## **Objections & Concerns**

The developers and their agents now acknowledge that there is a general presumption against new buildings in the Green Belt and this site, that of the former Castle Hill Hotel, lies in the Green Belt and within the curtilage of a Scheduled Ancient Monument and a designated local nature reserve.

Drawing
Proposed Site Plan

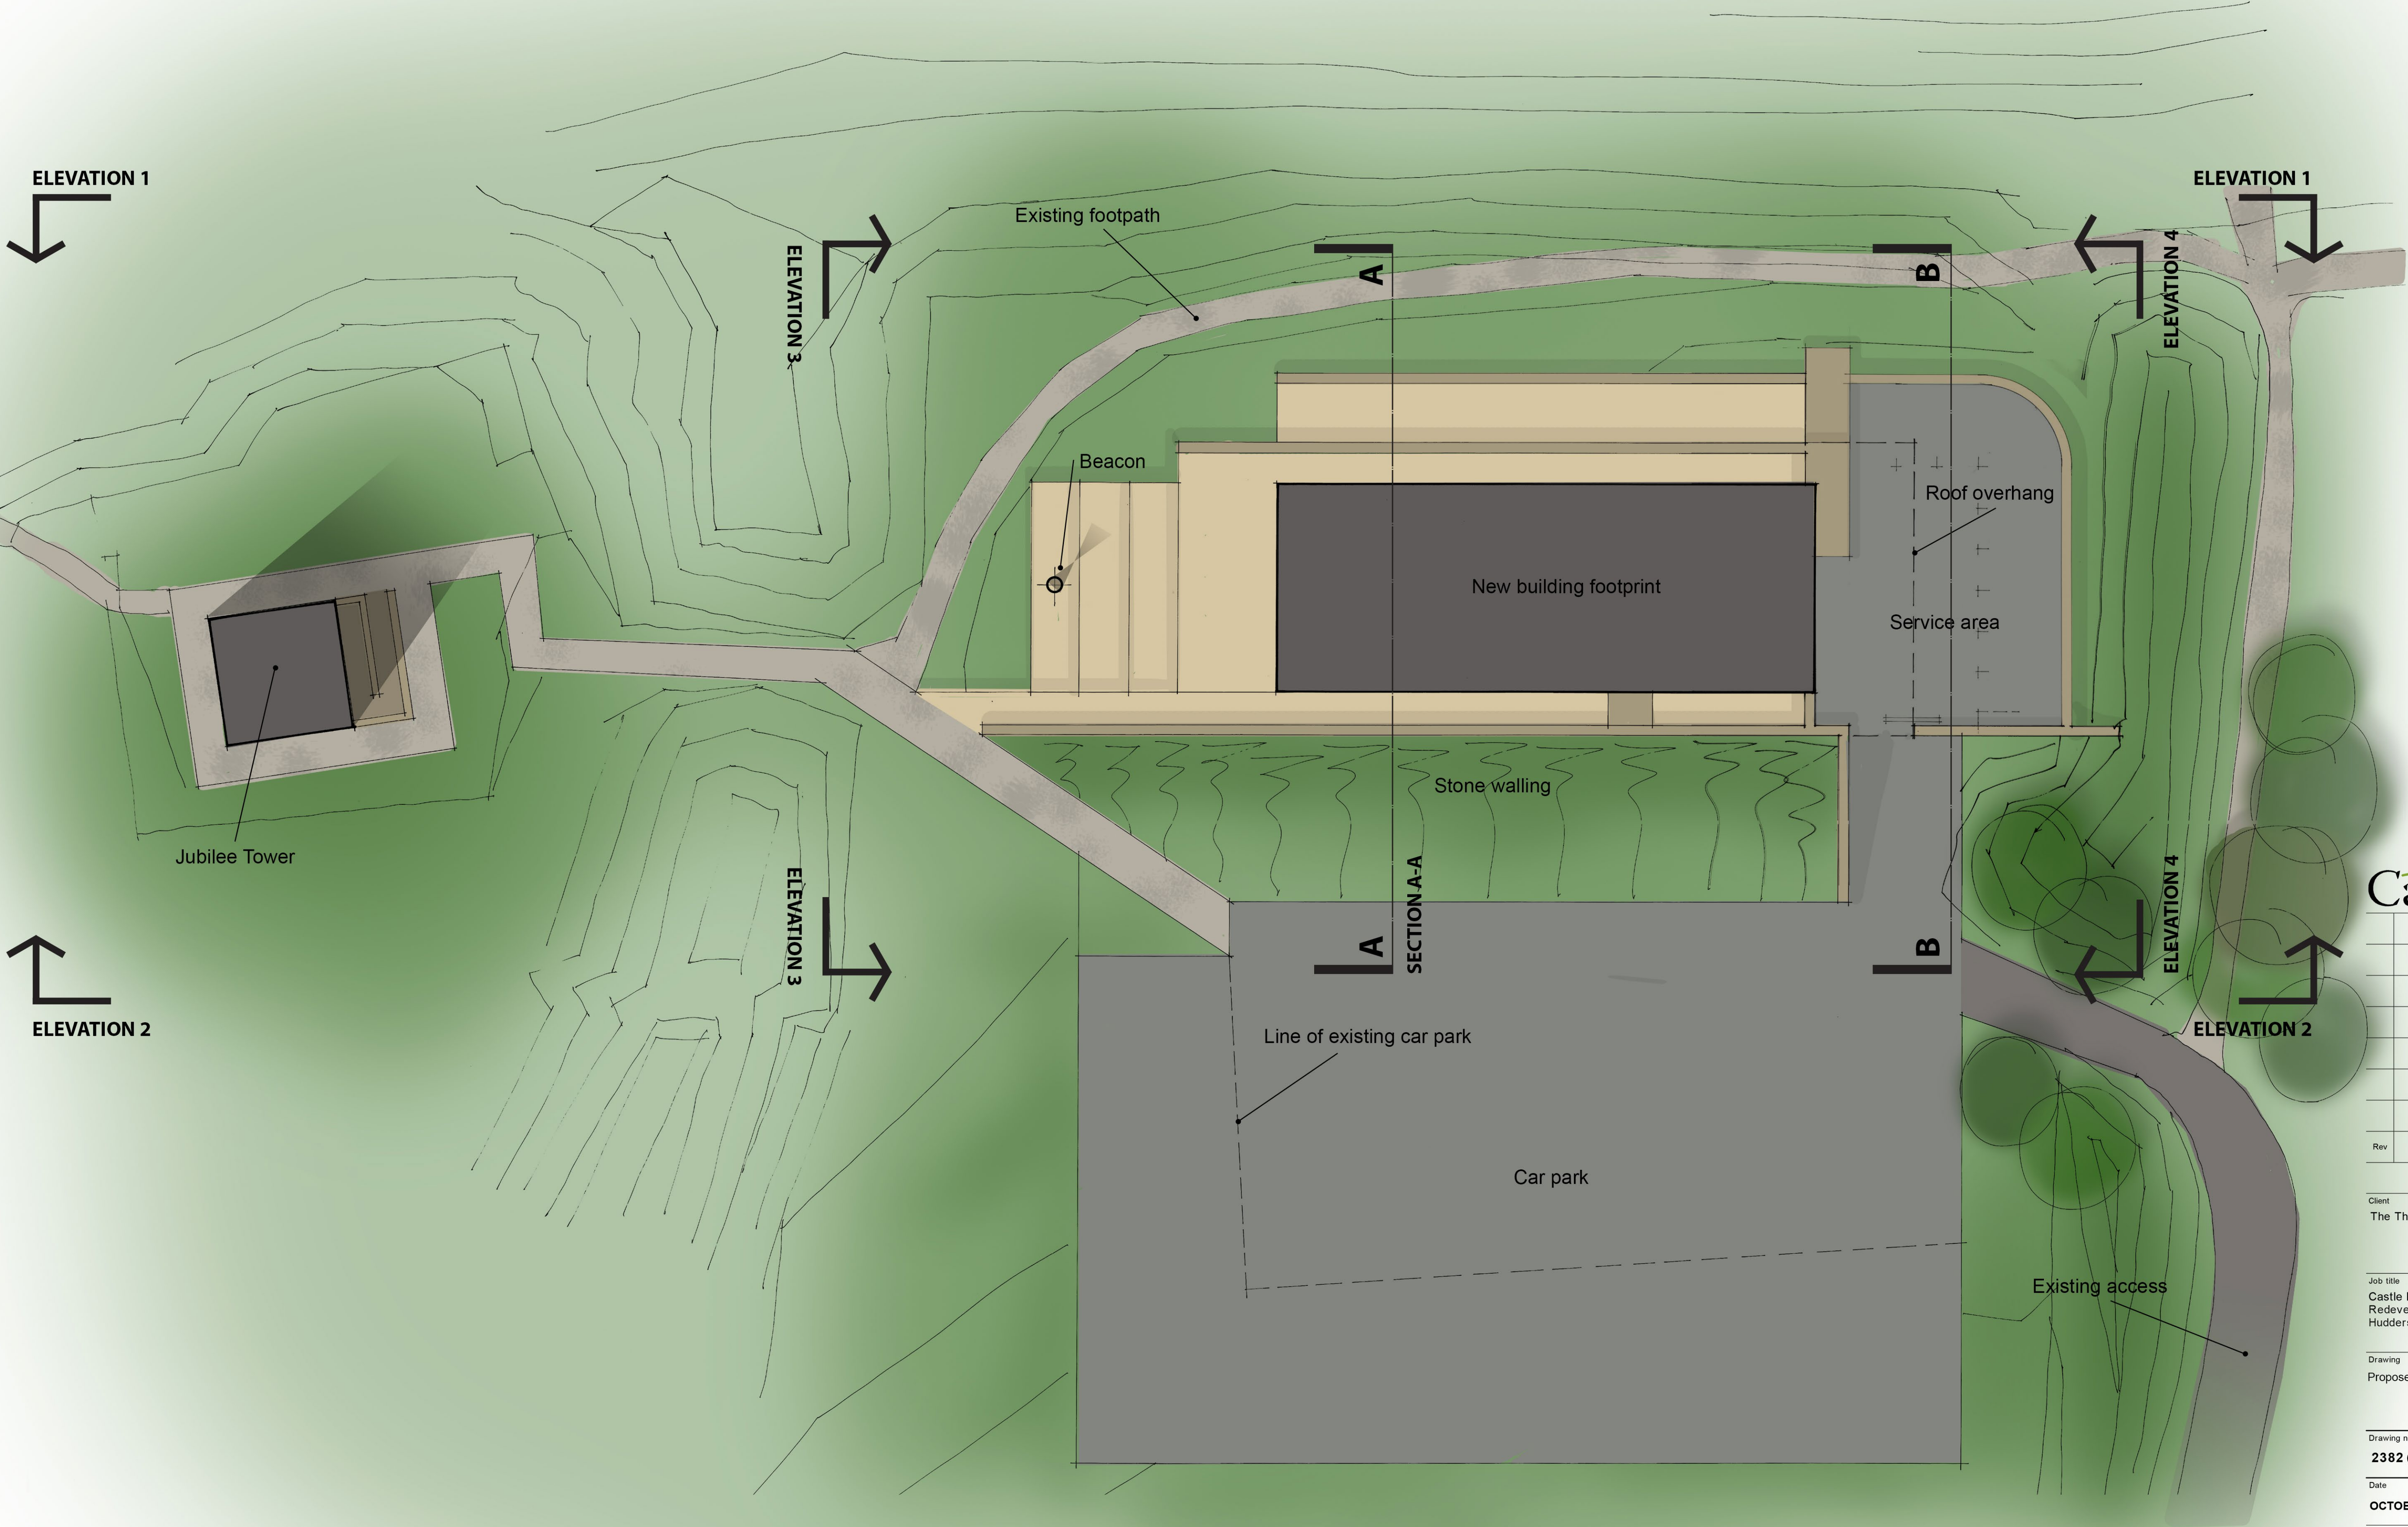
The site is seen as a major tourist attraction for the borough and the area, and yet the development reduces the number of car parking spaces available by 25%. There are 37 spaces. Many of the available spaces will be occupied by some of the 30 FTE employees (there are only nine spaces available in the service yard. Residents of the six double bedrooms would compete with diners in the 92 cover restaurant /cafe and those enjoying drinks on the terrace. And, we have not considered the family visitors just out to enjoy the fresh air, the views and the archaeology of the site. The developers acknowledge that at times, the hill and the access road may be congested and offer to control traffic flows up and down the hill. Might they restrict access to those attending functions at the restaurant?

INDICATIVE SIGNING AND LINING DETAIL

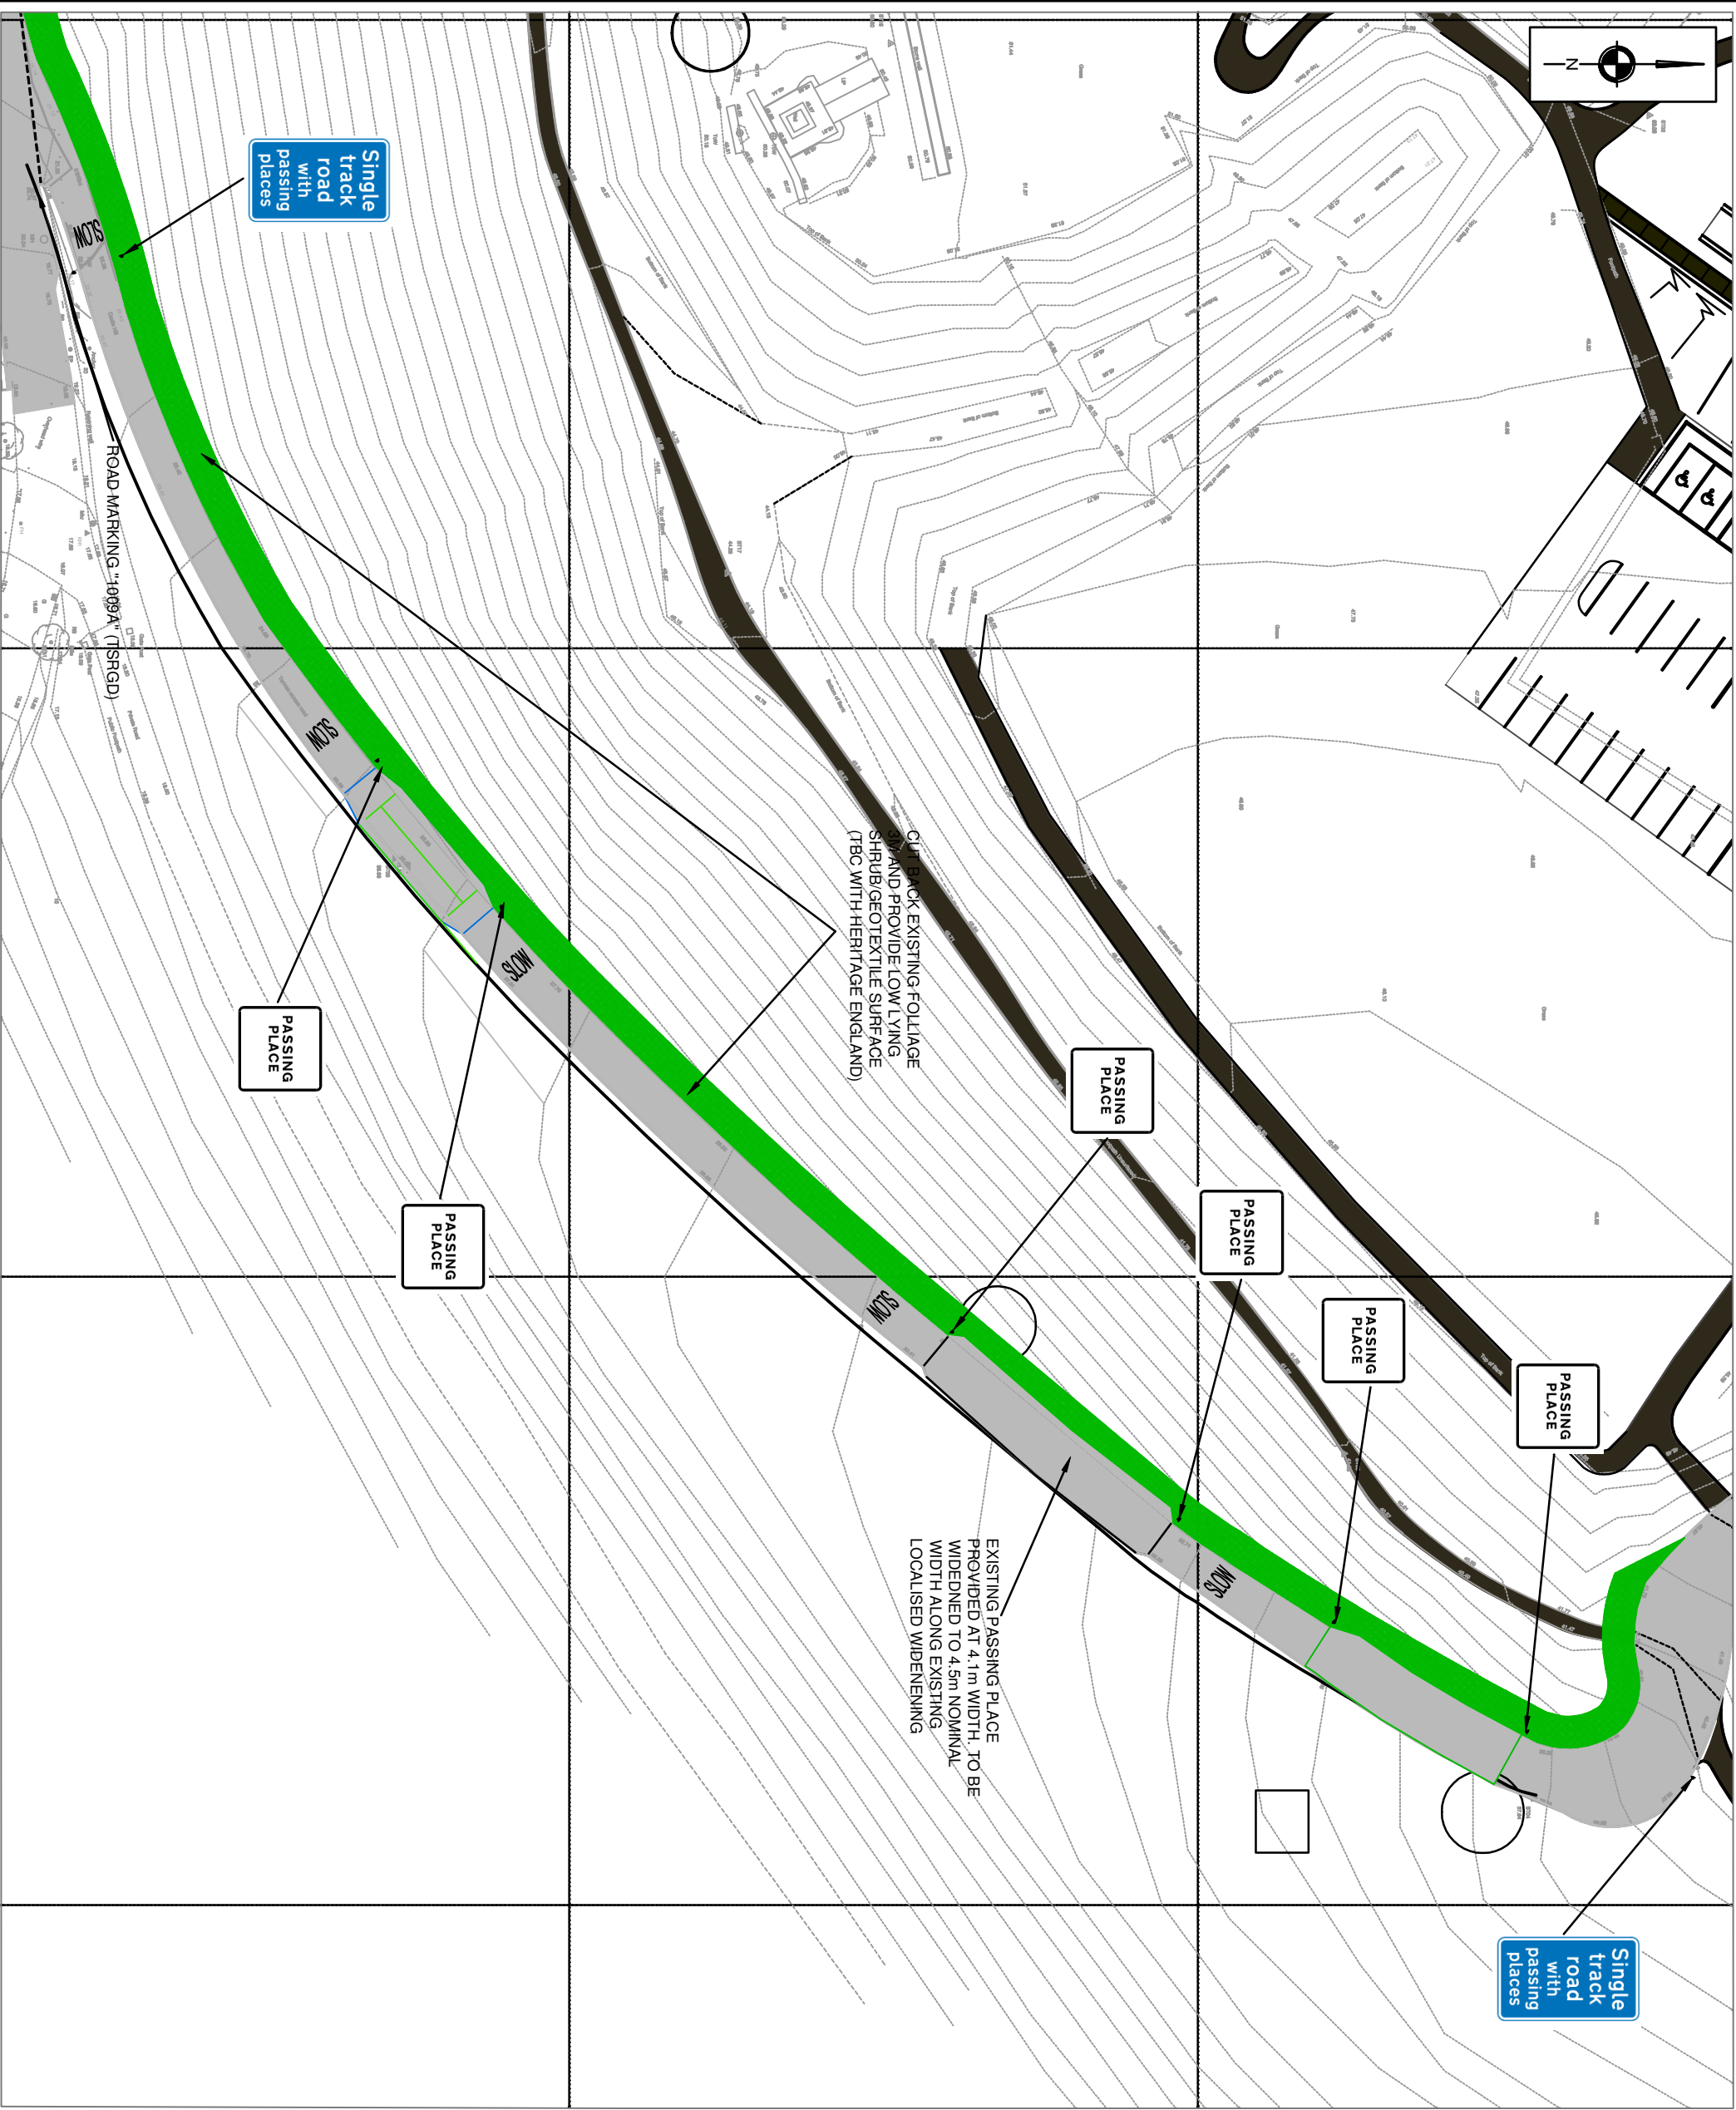
Access to the hill is poor. Organised functions, like conferences and weddings, would intensify traffic flows and congestion on the hill and surrounding roads. The proposal to create three passing points on the access road is unacceptable as it would involve cutting into the earthworks forming the monument.
